**NORTH FALLS OFFSHORE WIND FARM DEVELOPMENT CONSENT ORDER**

**PINS REFERENCE EN010119**

**DEADLINE 5: PORT OF LONDON  
AUTHORITY'S RESPONSE TO EXAMINING  
AUTHORITY'S SECOND WRITTEN  
QUESTIONS**

Deep Water Route Cable Installation Areas (Future Dredging Depths) Plan

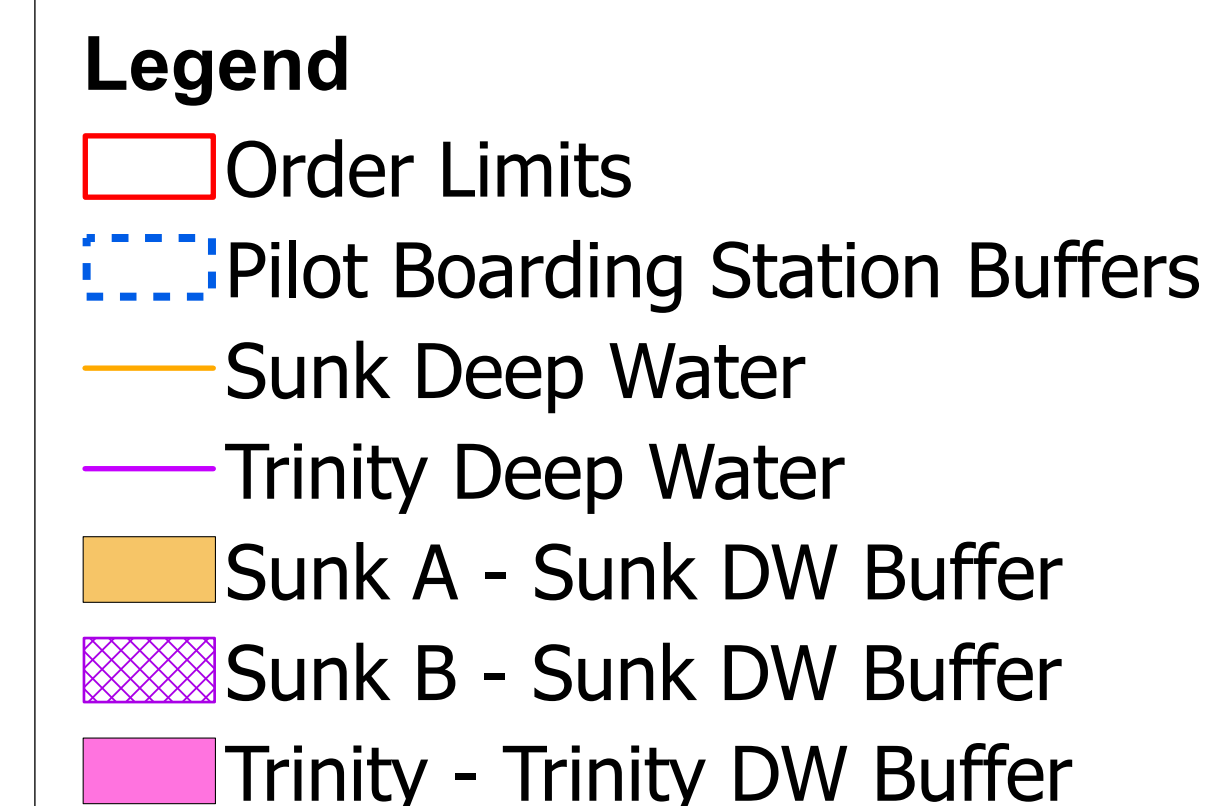
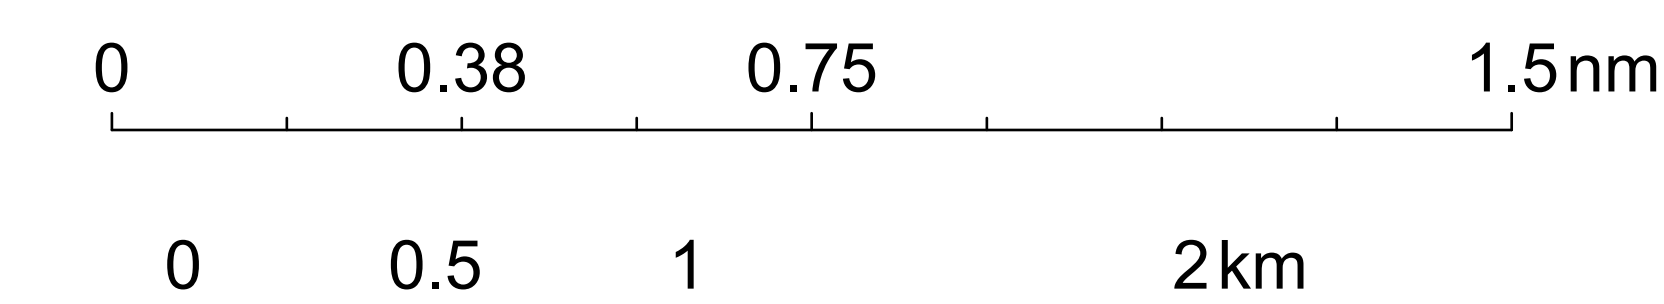
As set out in the PLA comments on deadline 4 submissions the area for deeper cable burial has not yet been agreed.
<b>9.2 Schedules 8, 9 and 10 – Deemed Marine Licence under the 2009 Act</b>			
Q9.2.1	MMO, MCA, PLA and London Gateway Port Limited	<b>Depths in the Deep Water Routes</b>  The question of the permissible water depth reduction was discussed at the ISH2. The dDCO (Rev 5) [REP4-004] has been amended at Condition 12 (3) of Schedules 8 and 10 and Condition 13 (3) of Schedule 9 to include further wording in respect of the water depth not being reduced by more than 5% Chart Datum when carrying out maintenance activities. Please confirm if the amendments now made are acceptable and address the concerns raised.	The amendments made are not acceptable. Please refer to the PLA's comments on the submissions received at Deadline 4, Paragraph 11.2 (b) to (h) which sets out the changes the PLA required to the DML.

<p>the dDCO at deadline 4 [REP4-004]. The applicant has included a new Requirement 2(3) in the dDCO submitted at Deadline 4. In addition, the applicant has made changes to the Deep Route Cable Installation Areas (Future Dredging Depths) Plan [REP4-043], the Outline Cable Specification and Installation Plan [REP4-039], the Outline Sediment Disposal Management Plan [REP4-038] and updated Navigation and Installation Plan [REP4-012]. Updates have also been made to the DML conditions to make reference to these plans. The applicant's position is that protective provisions are not necessary, appropriate or reasonable in the circumstances, and would be unprecedented.</p>	
		<p>(i) Given the additional measures secured by the Deadline 4 updates to application documents, please can LGPL and PLA indicate whether they still seek protective provisions and, if so, explain why the package of mitigation measures committed to by the applicant would not appropriately address their concerns and whether there are any other mitigation measures in relation to the Sunk and Trinity DWR and Sunk Pilotage area that would preclude the need for protective provisions.</p>	<p>The core purpose of protective provisions is to prevent serious detriment arising to statutory undertakings from exercise of DCO powers. This is exactly what the PLA is seeking to achieve through its protective provisions.</p> <p>There is the potential for significant impact on the Port of London which is the largest Port in the Country. The PLA has actively engaged with the examination process and has commented on the oNIP, the oCSIP and the oSDMP, with the production of the latter documents as a result of the PLA's engagement in the examination process. The PLA has also engaged with the Applicant over the area required for deeper cable burial and has set out the changes that are required to that plan that is to become a certified document. The PLA has an important role in ensuring that the cables are installed and maintained at a depth that do not cause long term detrimental impacts on the Port of London and that the oNIP, the oCSIP, the oSDMP are fit for their intended purpose.</p> <p>The PLA has specific comments on the Mitigation Plans which are being discussed with the Applicant. The additional measures "secured" in these documents do not, however, appropriately address the PLA's concerns on their own for the following reasons:</p> <p><b>1. There is scope for the final Mitigation Plans to change</b></p>

- (i) shown shaded in yellow and outlined in a bold black line (and labelled Sunk Area A (22m CD)) to a level of 22 metres below Chart Datum;
  - (ii) shown shaded in yellow and outlined in a blue dotted line (and labelled Trinity (22m CD)) to a level of 22 metres below Chart Datum; and

- (iii) shown shaded in yellow and cross hatched in orange (and labelled Sunk Area B (19m CD)) to a level of 19 metres below Chart Datum.];
  - (iv) and in all cases (i) to (iii) makes allowance for an ‘over-dredge’ tolerance of 0.5 metres in addition to the stated depths attributable to standard dredging methodology.
